Roadway Plans_V1.pdf Markup Summary

CLEARWAY FILING NO. 2, LOT 5

CONSTRUCTION PLANS

**STORM 2**  
**STA 1+00.00 TO STA 4+41.70**

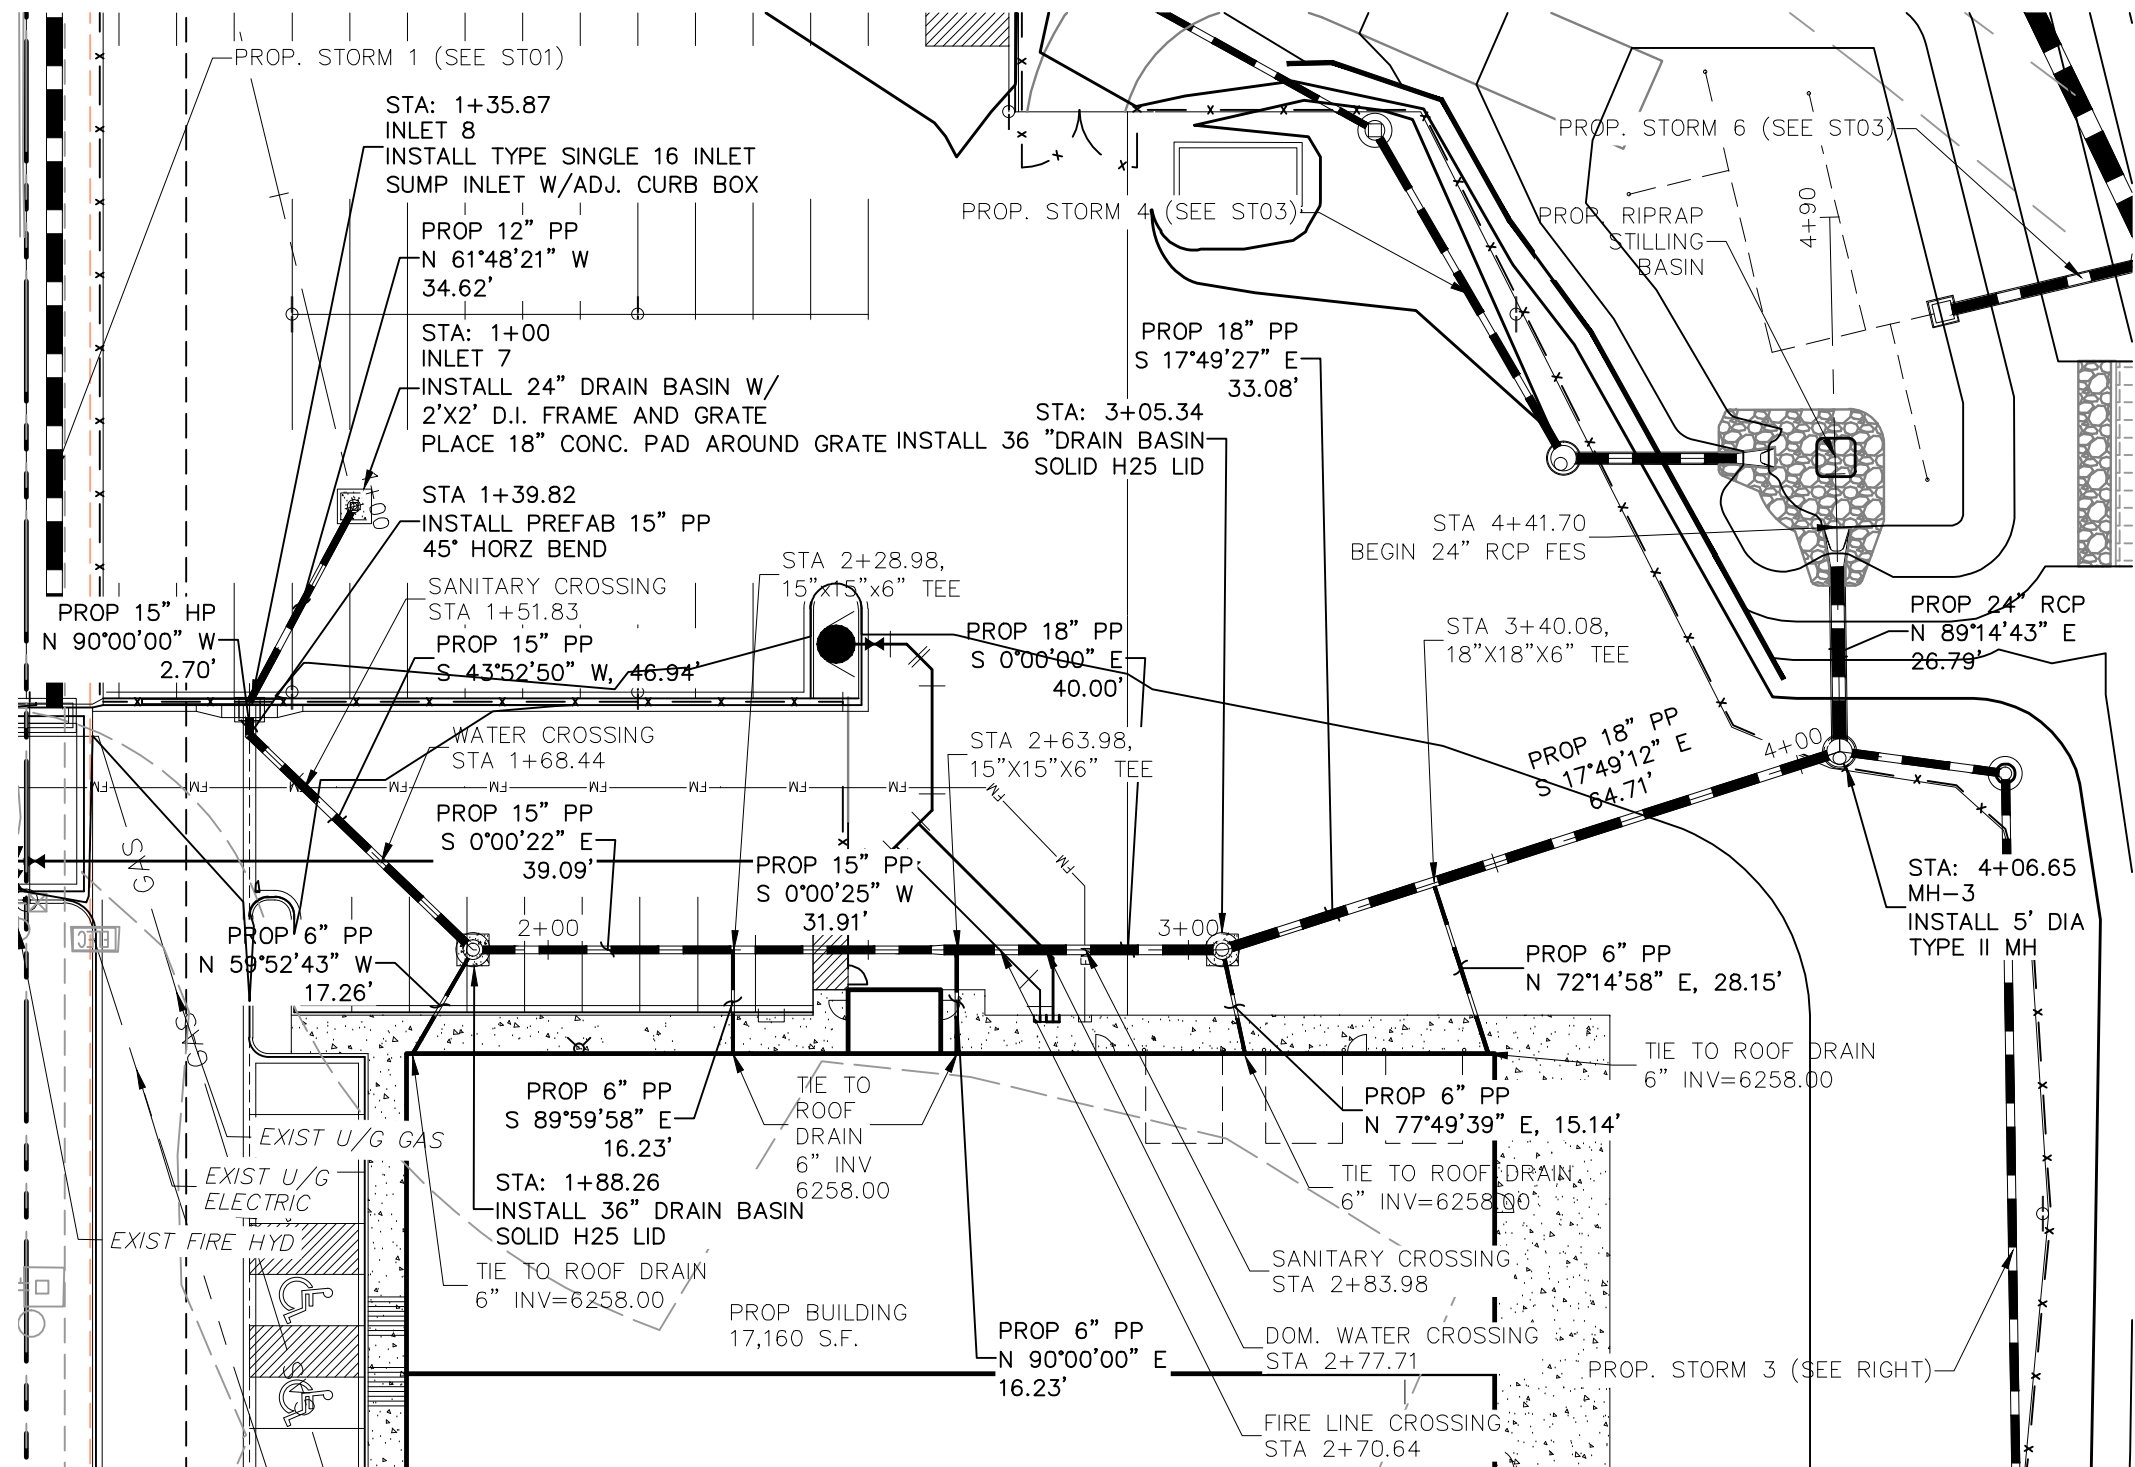
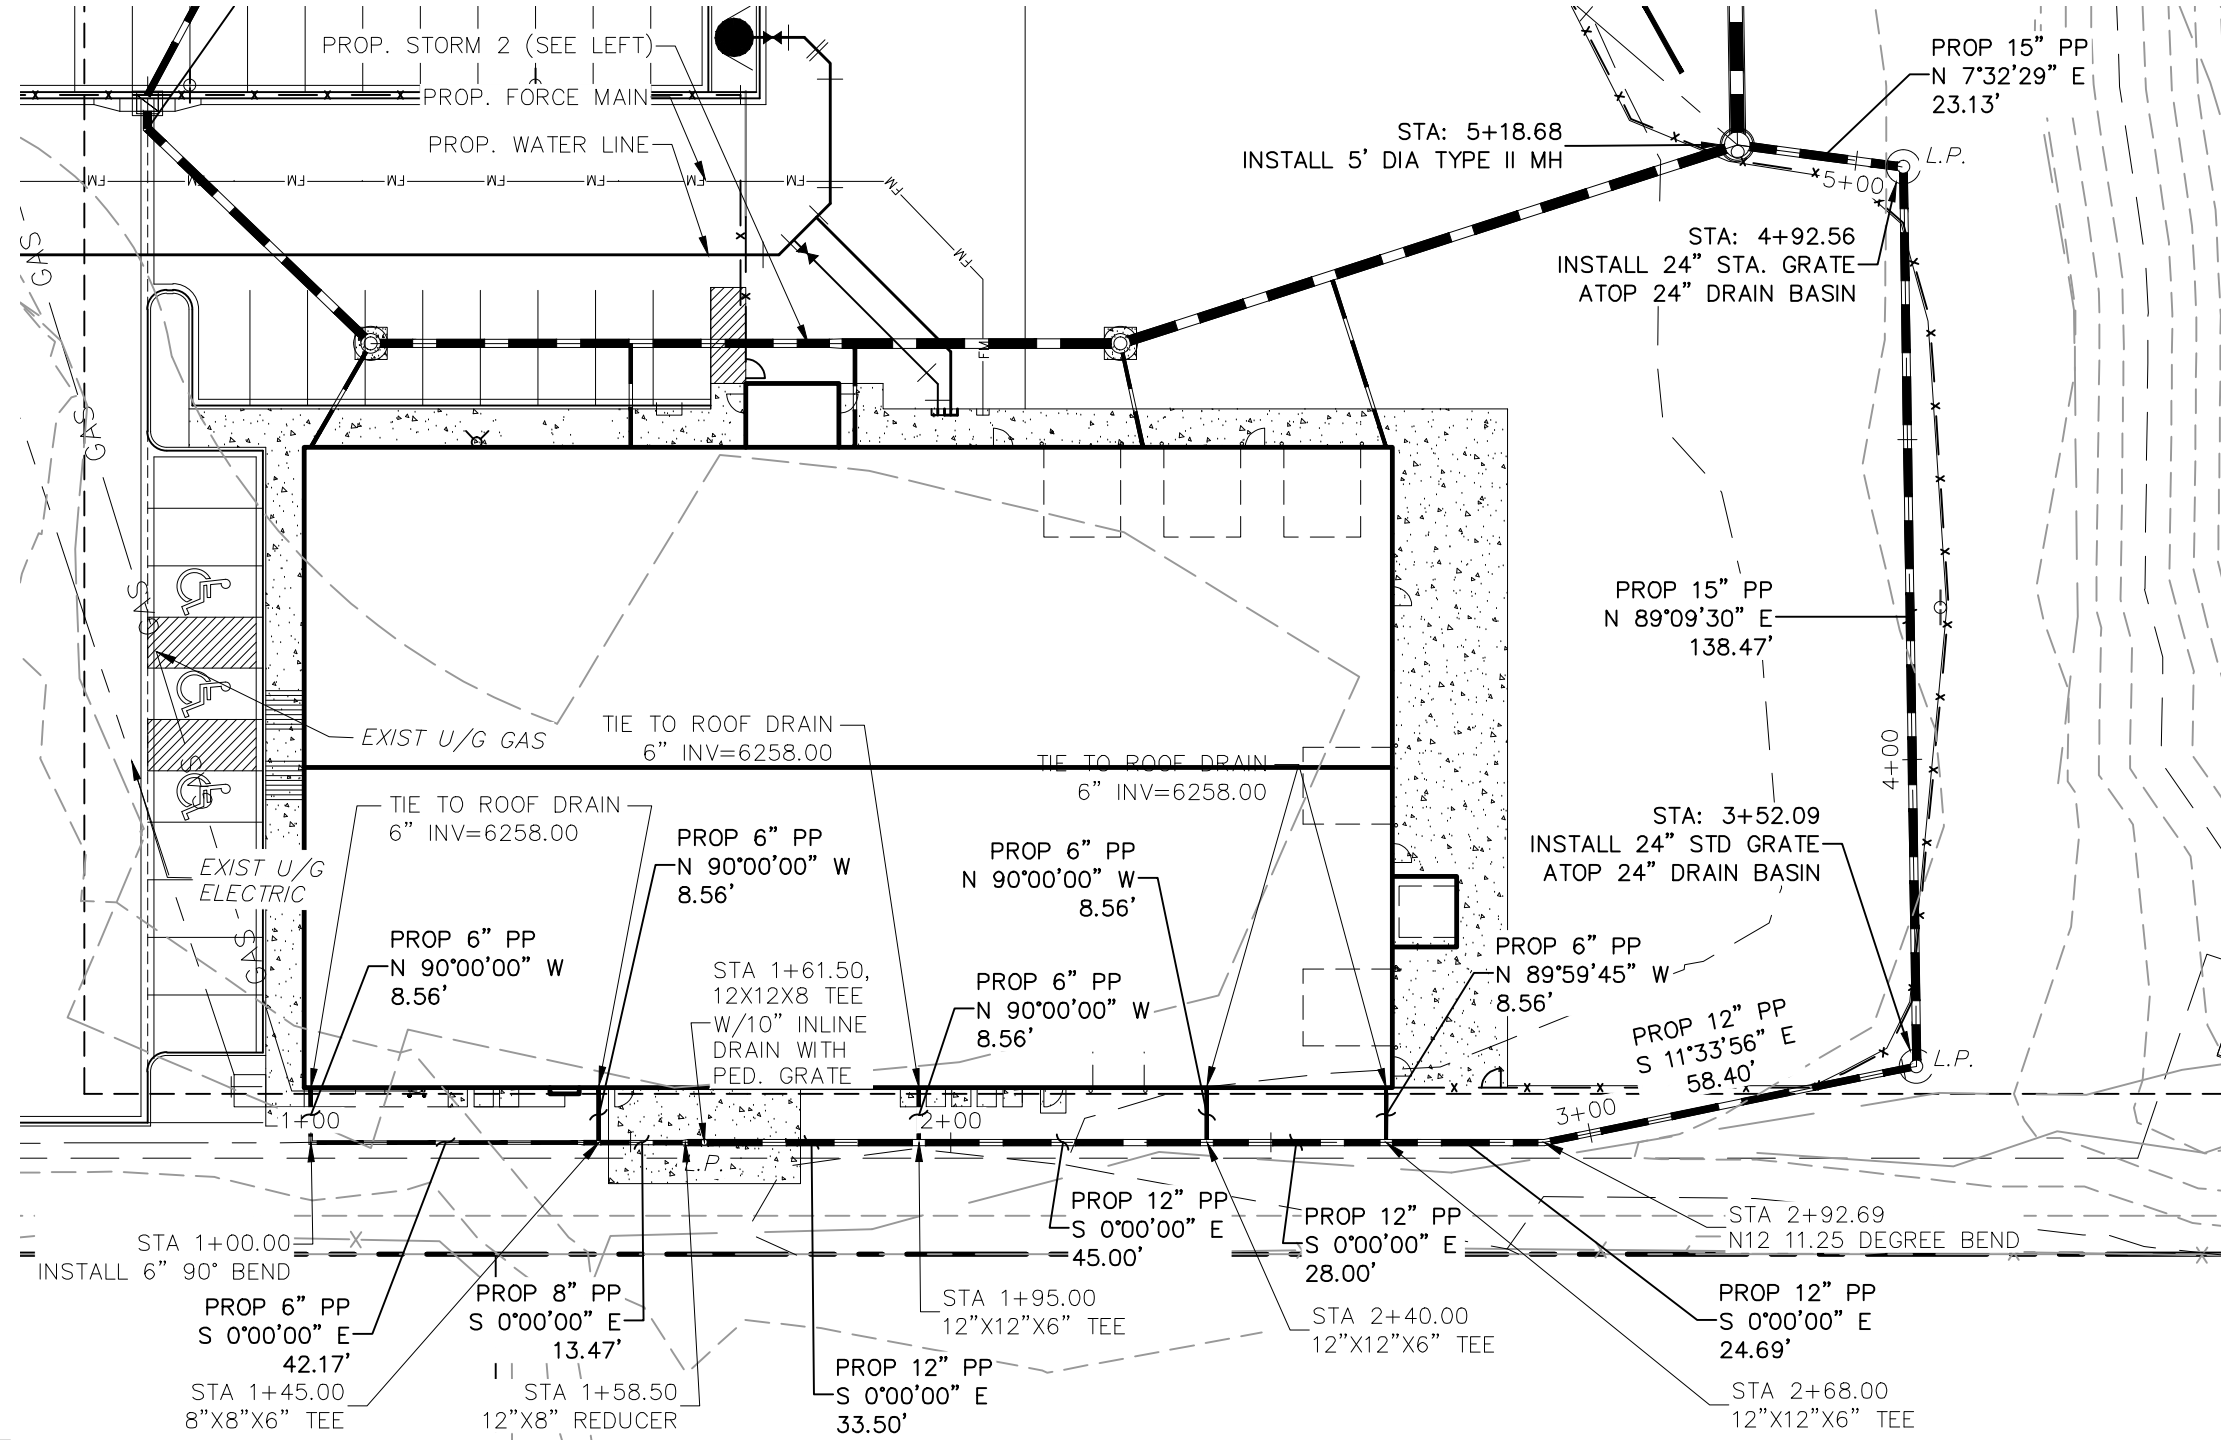
Show HGL lines on the profiles.

provide vertical scale

identify the depth of the basin
